### CITY OF ALBUQUERQUE PLANNING DEPARTMENT October 16, 2013 DRB Comments

PROJECT # 1004323

**APPLICATION # 13-70699**

RE: Lots 4-A & 6-A, Block 7, John Baron Burg Park

PLAT OF  
 Lots 4-A-1 & 6-A-1, Block 7  
 JOHN BARON BURG PARK  
 Section 7, T.10N., R.3E., N.M.P.M.  
 City of Albuquerque  
 Bernalillo County, New Mexico  
 September 2013

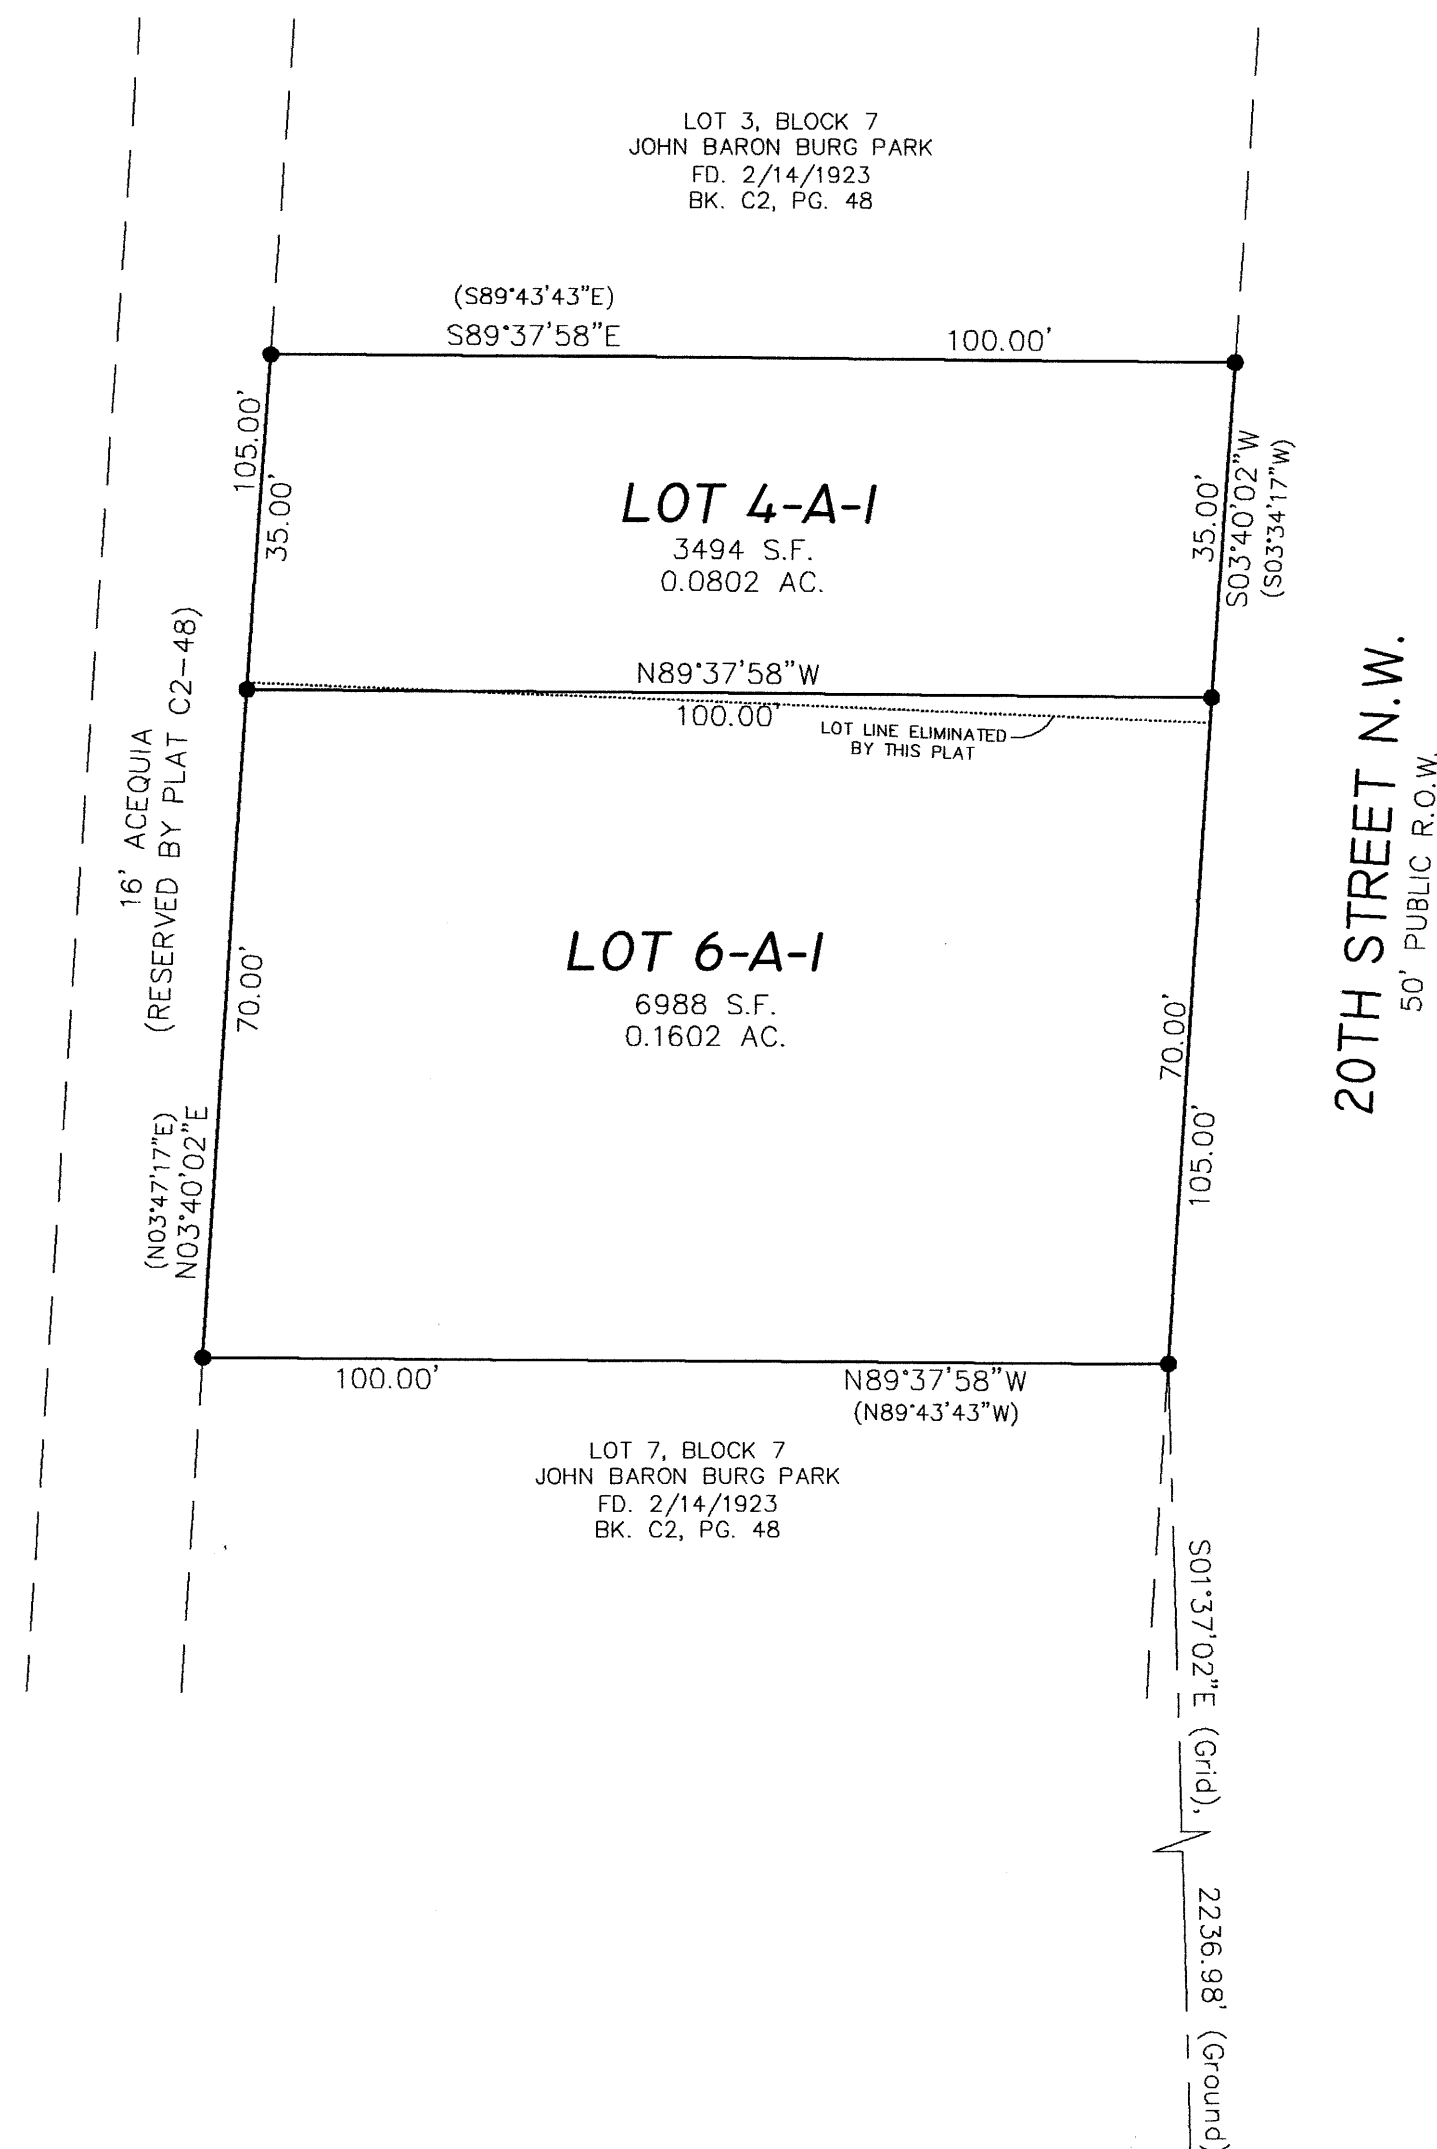
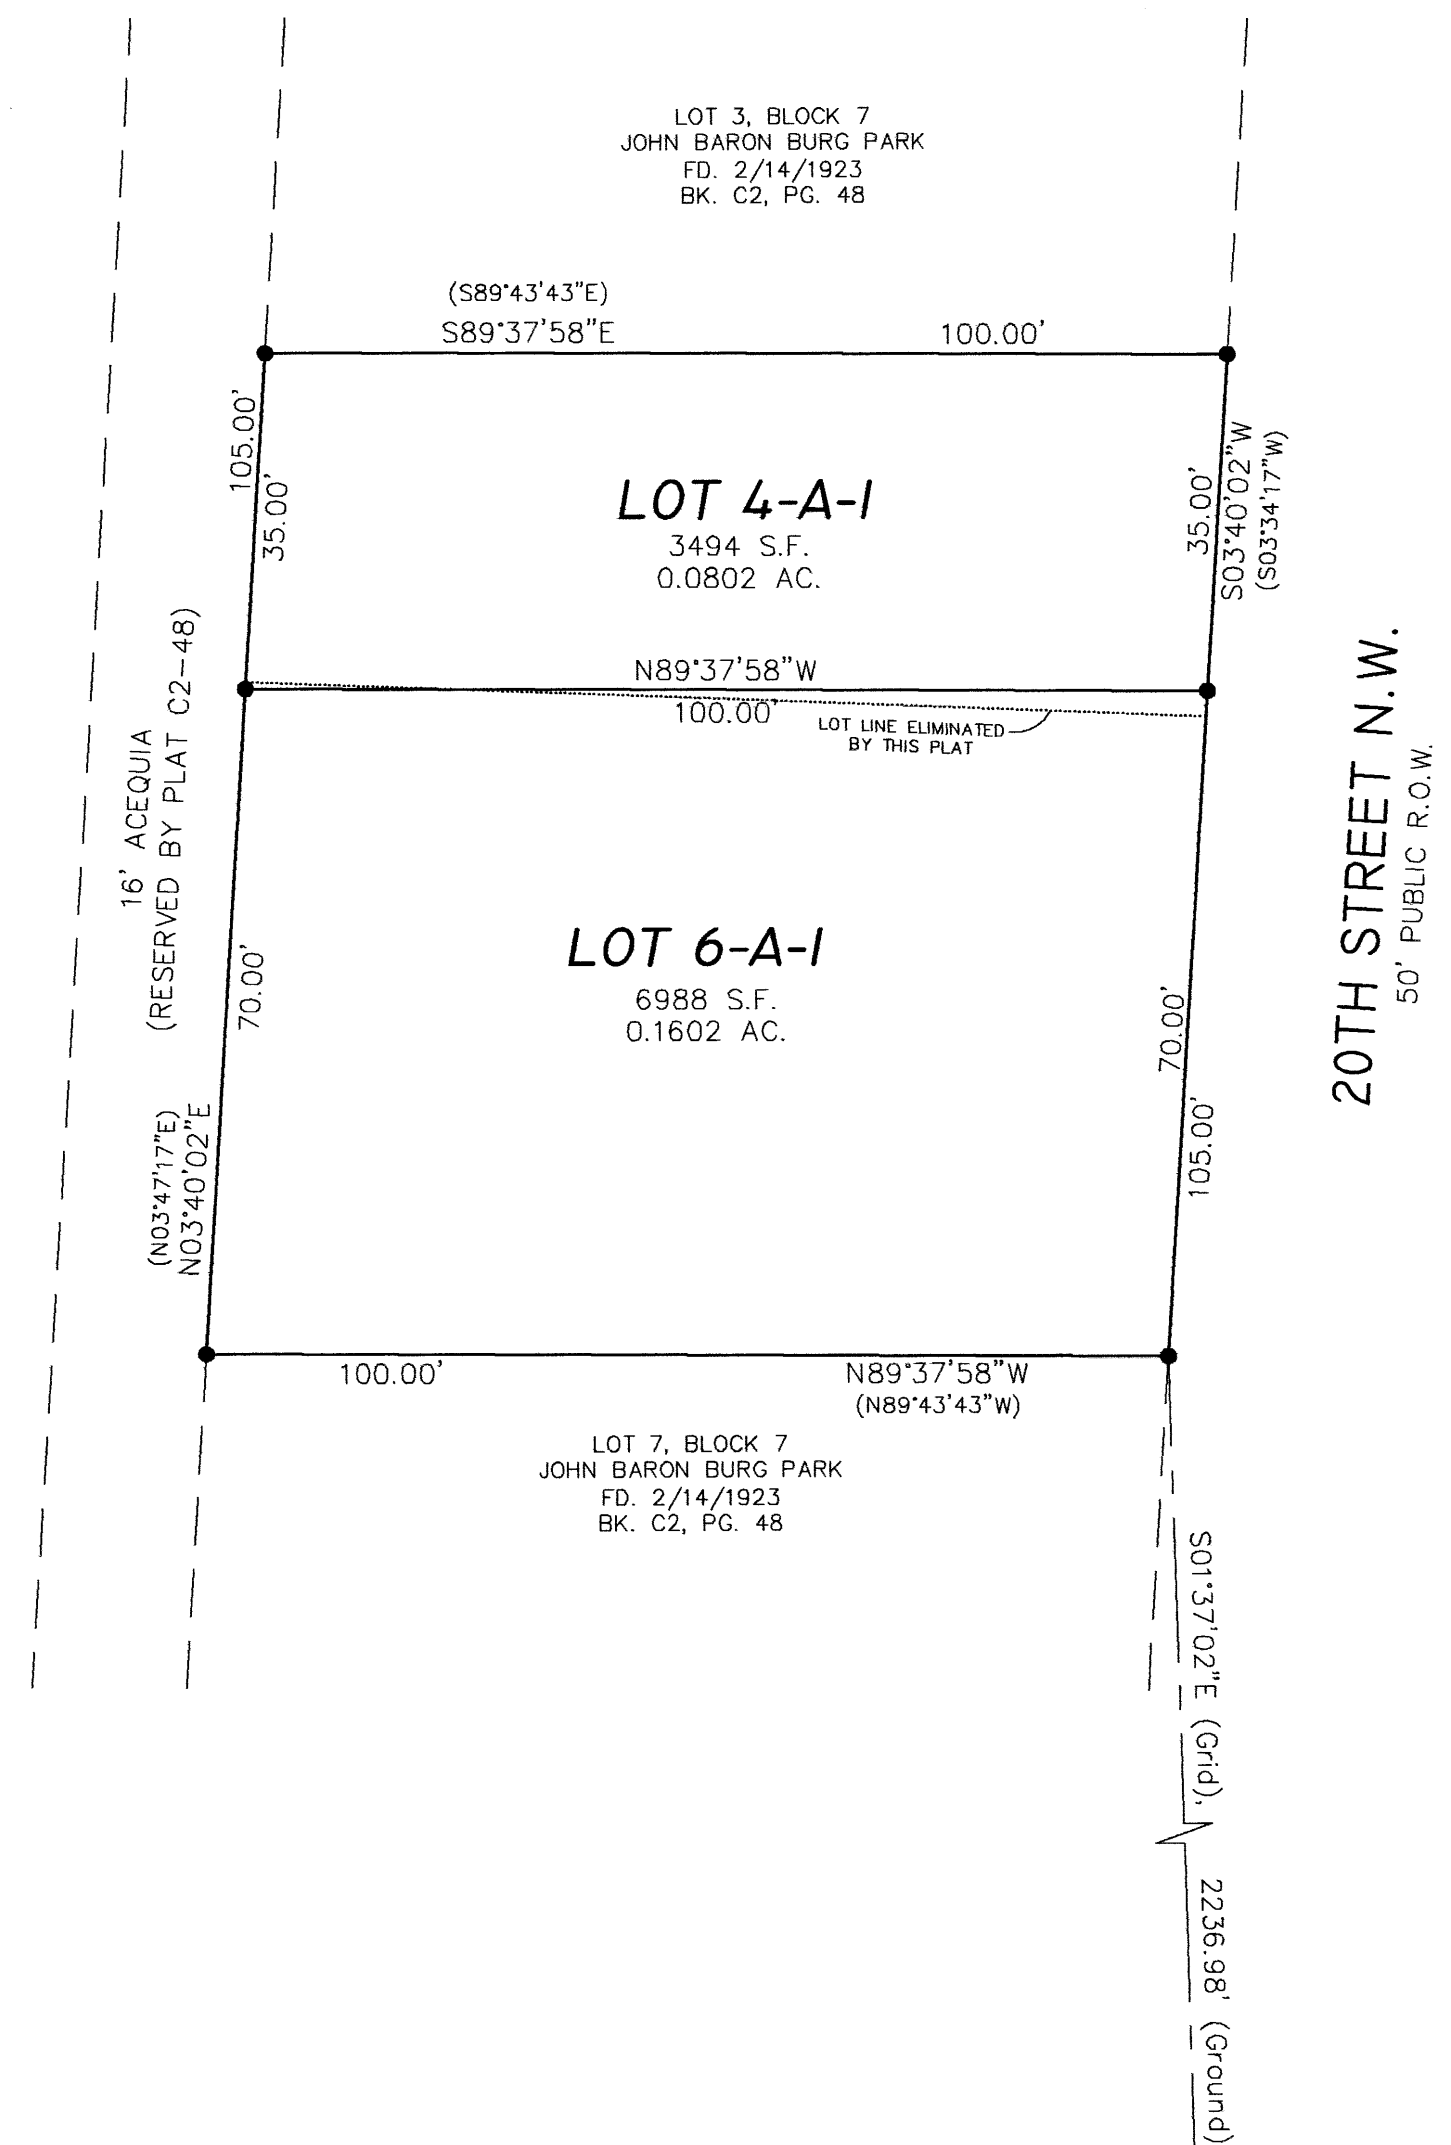
Proposed Lot 4-A-1 does not conform to minimum lot area requirement of the S-R Zone [§ 14-14-2-2 of the Subdivision Ordinance]; a lot size variance would be required.

If existing wall is not moved to coincide with proposed lot line, this plat would create unusable and un-maintainable space and thus would not comply with the other Fundamental Considerations of the Subdivision Ordinance [§ 14-14-2-1 and -3].
